Address: 48 Long Croft Street Huddersfield HD7 4EA

| Application number: 2025/92628   |                                                                        |
| What is the application for?:    | Erection of dwelling and associated works (within a Conservation Area) |

HOUSE TYPE 01 GA PLANS & ELEVATIONS 1:100 @ A1

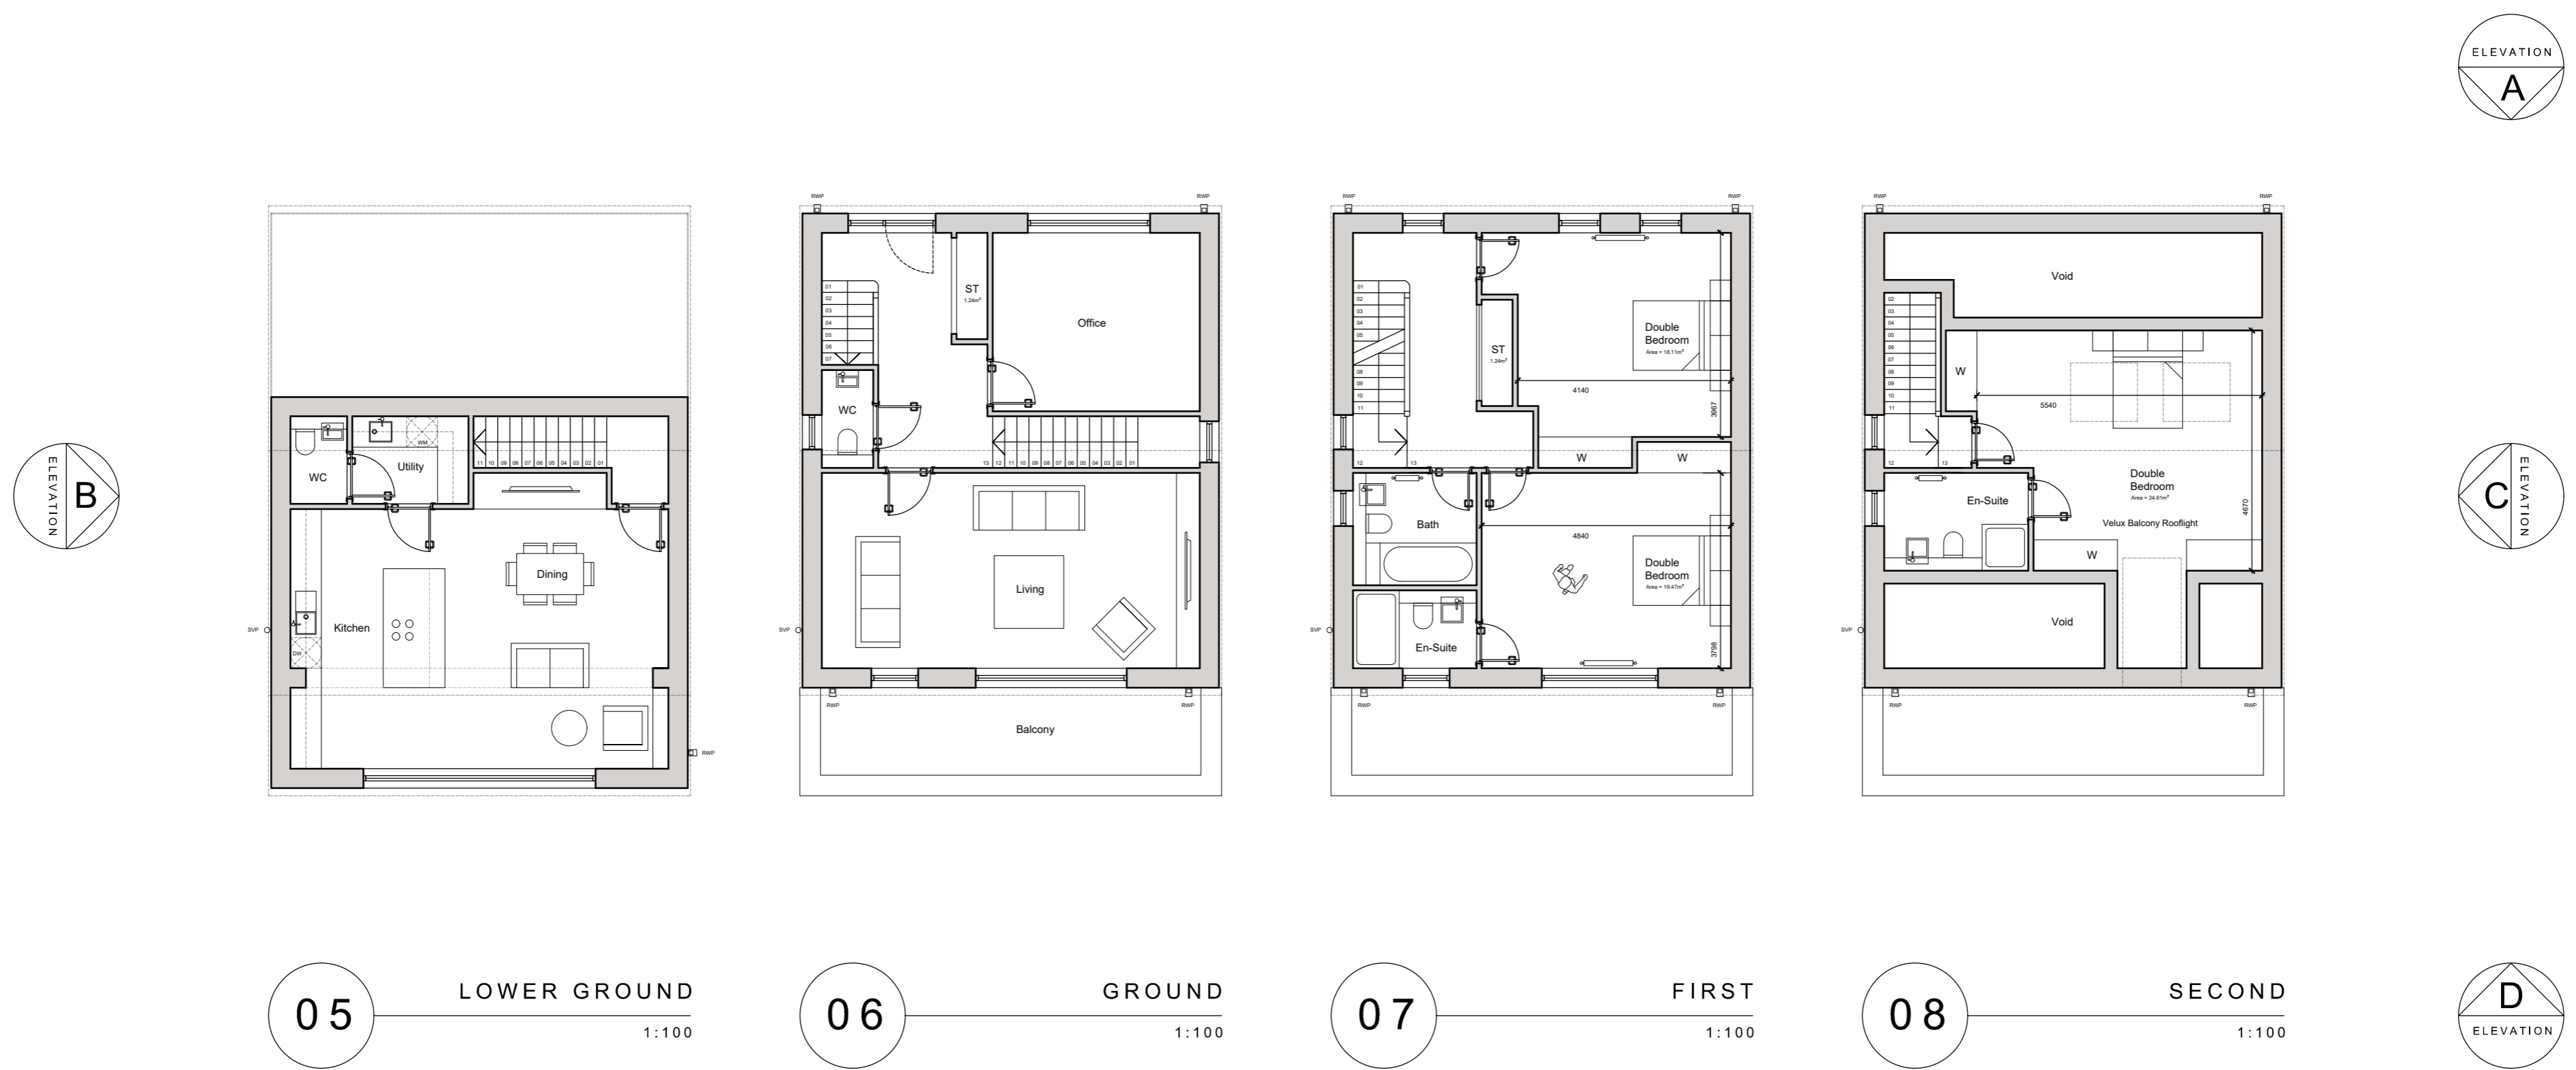
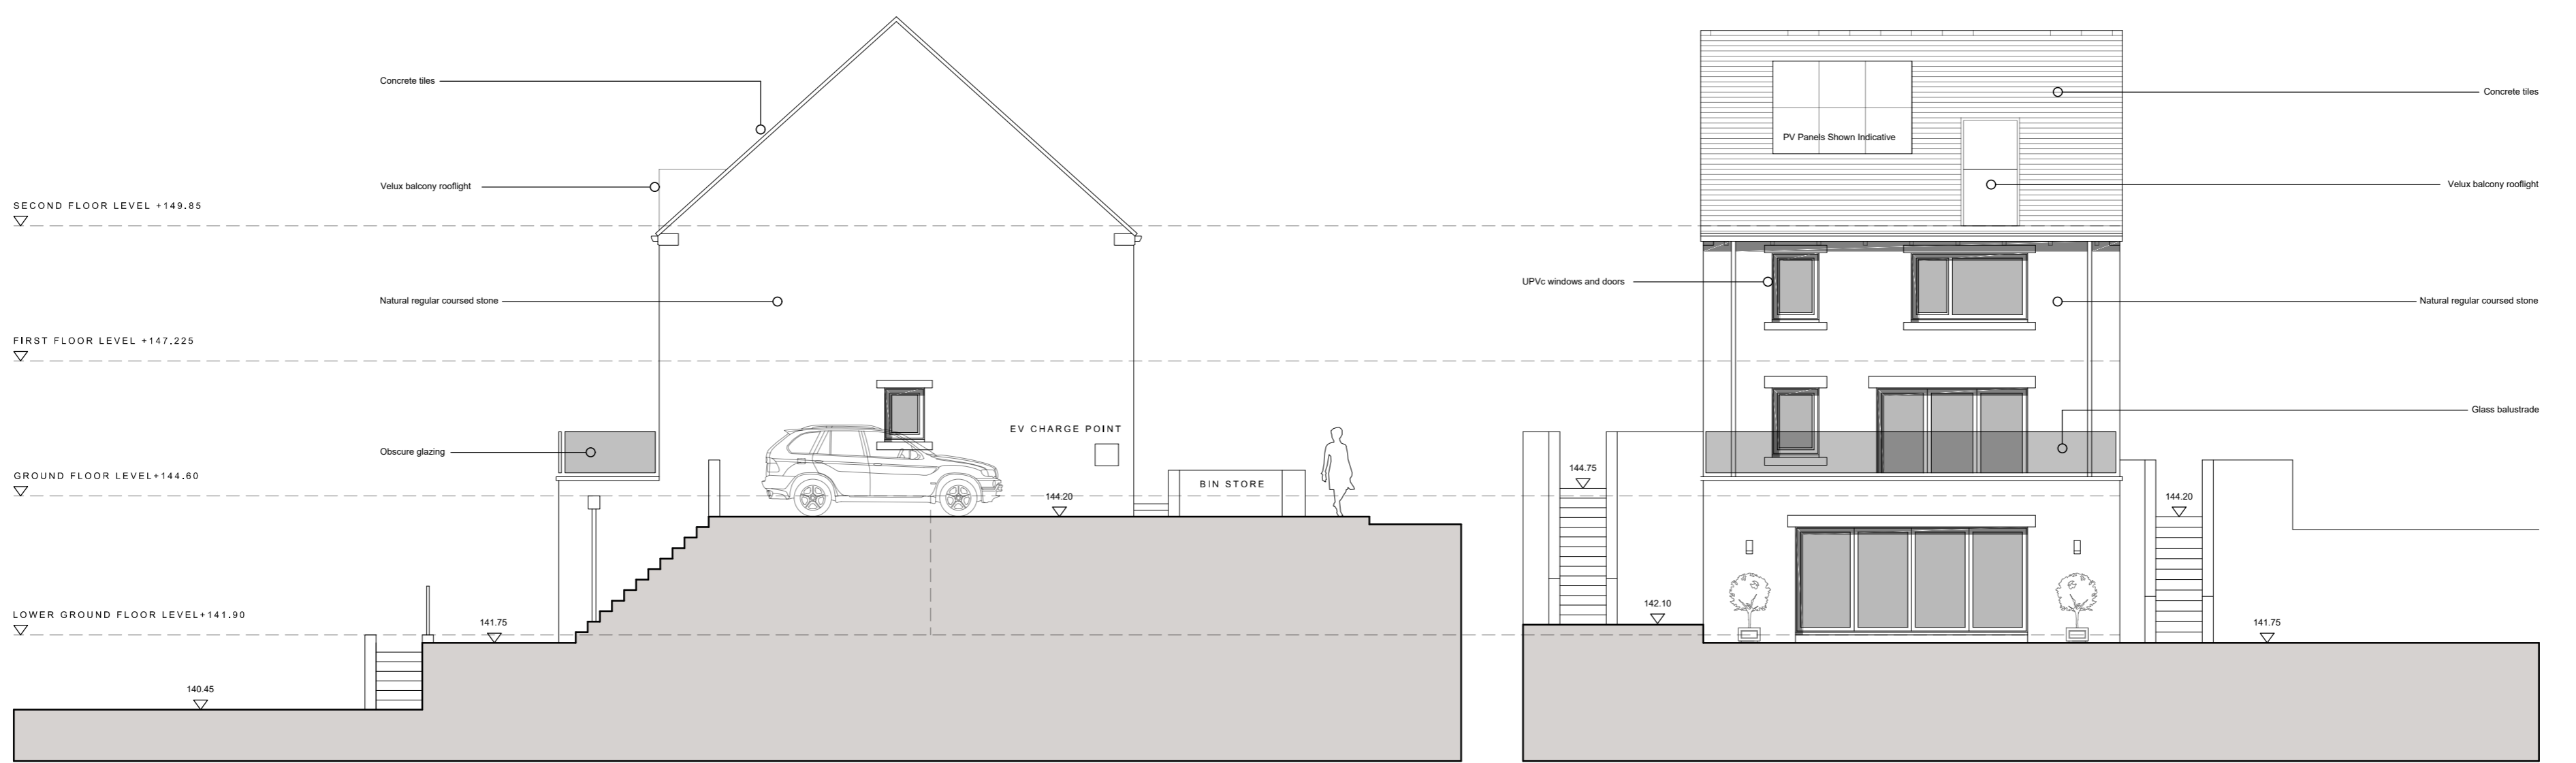
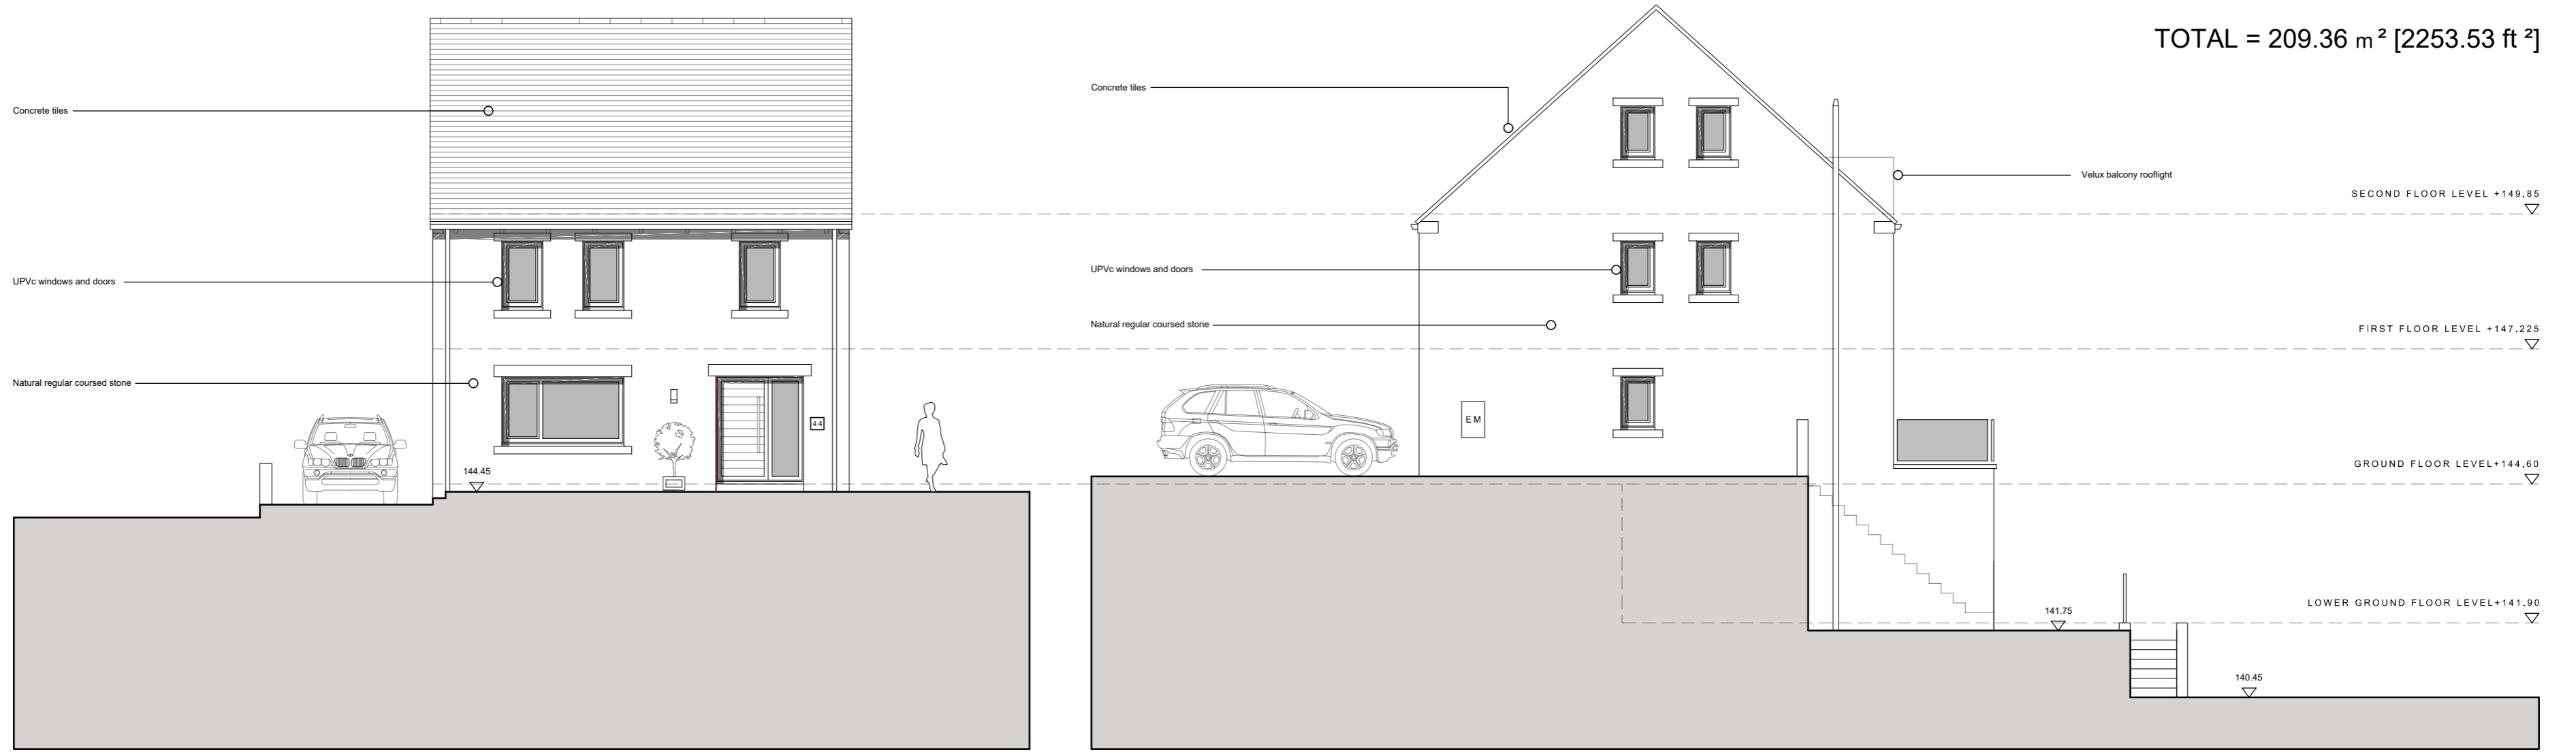
| <p>I am not against a house being built on this site as I think it would look better than it does now however this plan would mean that this house would not follow the line of those houses either side of it. In the valley side (not the road side ) the house would be coming out to far and thus would look out of place m, too dominating and not in keeping with the properties either side. I also understand that properties either side have not been allowed to be built with a balcony and conservatory's in the recent past as they came out to far and had the planning knocked back</p> |    |
